From: Sue Howell
Sent: 11 October 2017 16:56
To: Planning.Responses
Cc: David Easton
Subject: RE: Planning Consultation on: AB/77/17/PL

Comment from Greenspace

Site Address: Blastreat Limited and Adjoining Greenhurst
Fitzalan Road Arundel BN18 9JS

Description of Works: Demolition of existing dwelling & buildings.
Erection of a block of 45 sheltered apartments for the elderly (comprising 21 x one bedroom apartments and 24 x two bedroom apartments age restricted to 60 years and over); with associated access, electric buggy/cycle store, refuse bin store & 34 parking spaces. This application affects the character & appearance of the Arundel Conservation Area.

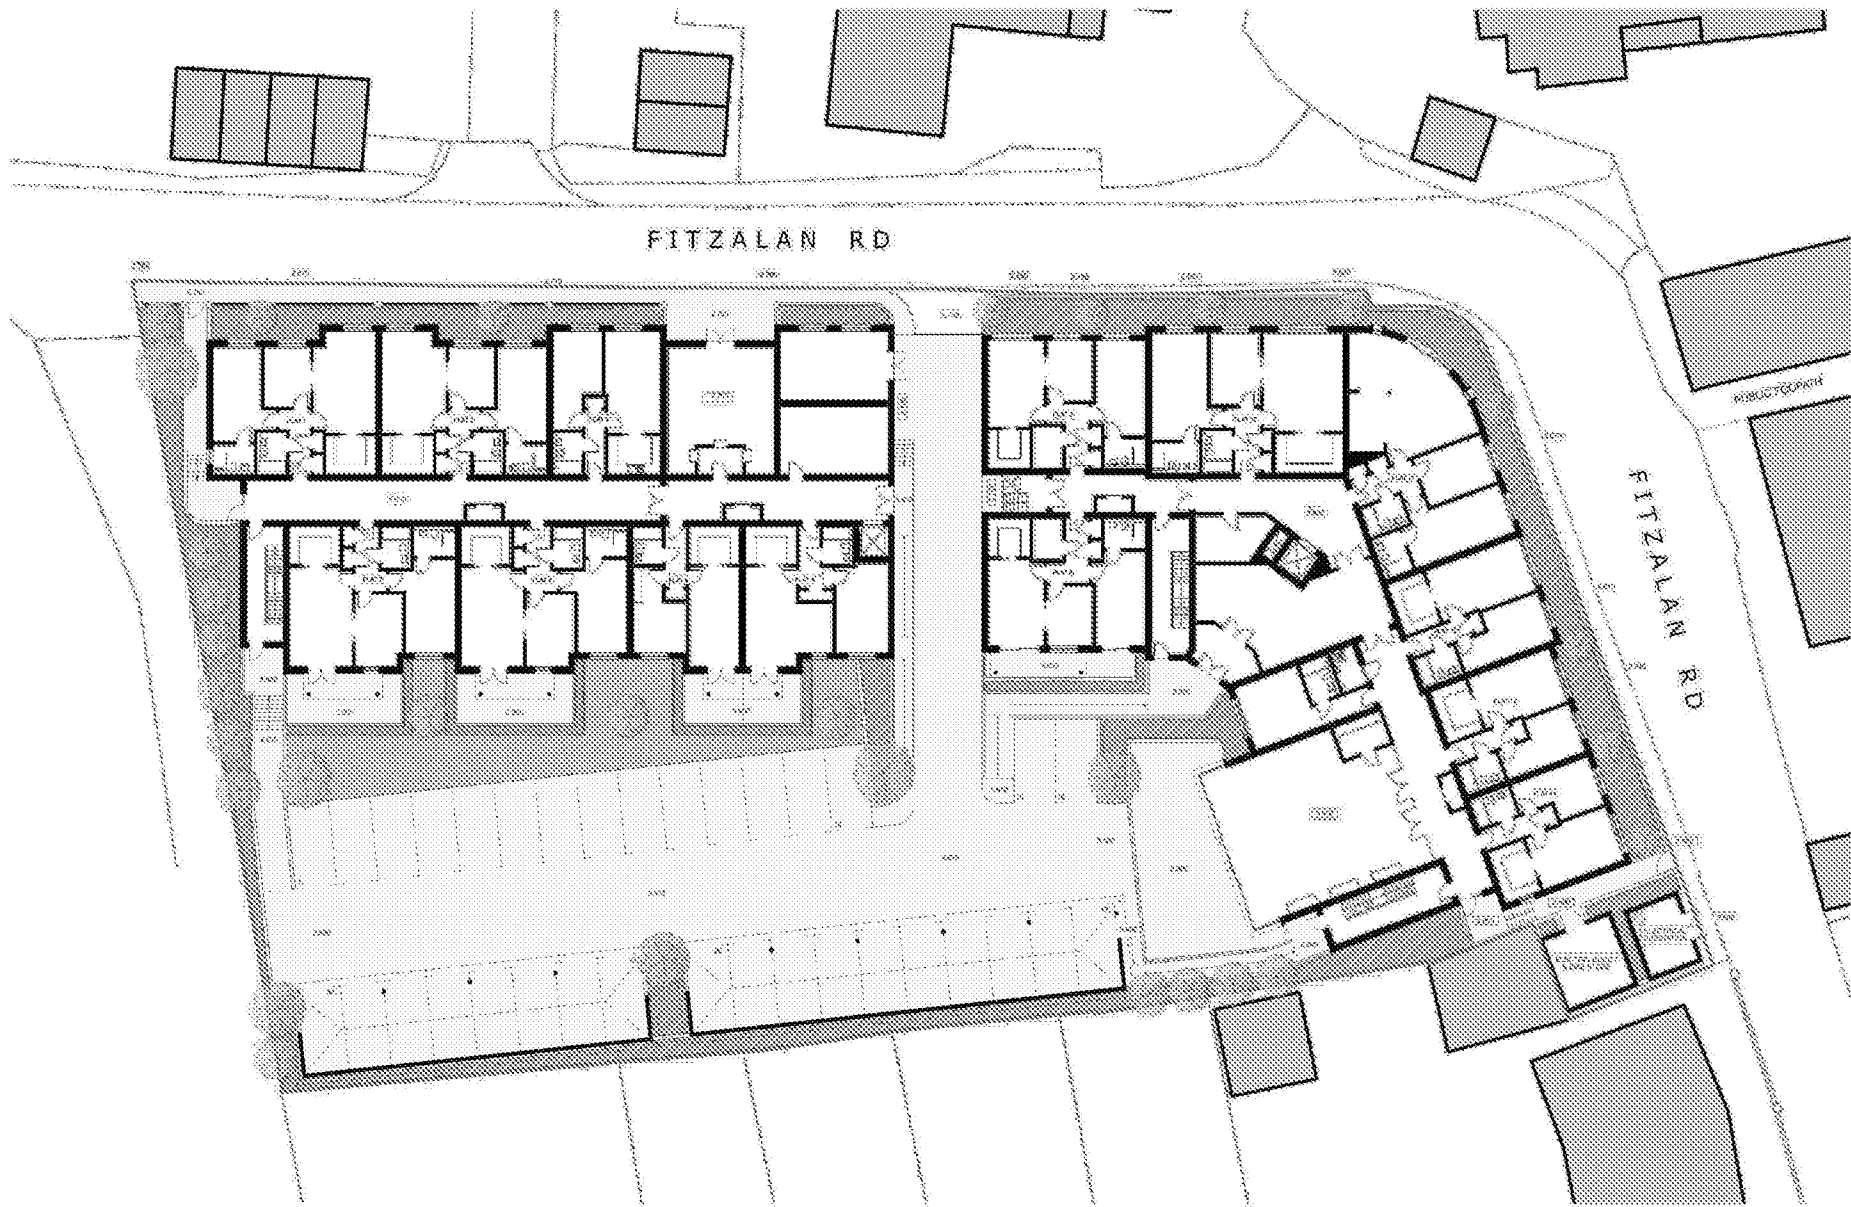
Whilst there has been a landscape plan produced LANDP001 this appears to cater for blocks of planting rather than allowing for the formation of garden areas which would allow the residents to dwell in such areas. Planting beds and specimen shrubs have been indicated which will give an element of greening, but certainly not great aesthetic benefit to what will be quite a hard scheme. The communal patio off the communal lounge appears particularly hard and for residents who may potentially be confined to these areas, the stimulation of what's outside would appear to be lacking.

It is appreciated that the nature of the site at present, and the lack of greening which it presently offers would lend to a situation where development could prove beneficial. It would however appear functional on completion as presently planned rather than aesthetically enhancing the green landscape offer.

My recommendation would be that the layout of this development is given further thought and improvements made to the landscape setting of this proposal. I would have to recommend an objection to the proposals on landscape grounds as they are presented at present.
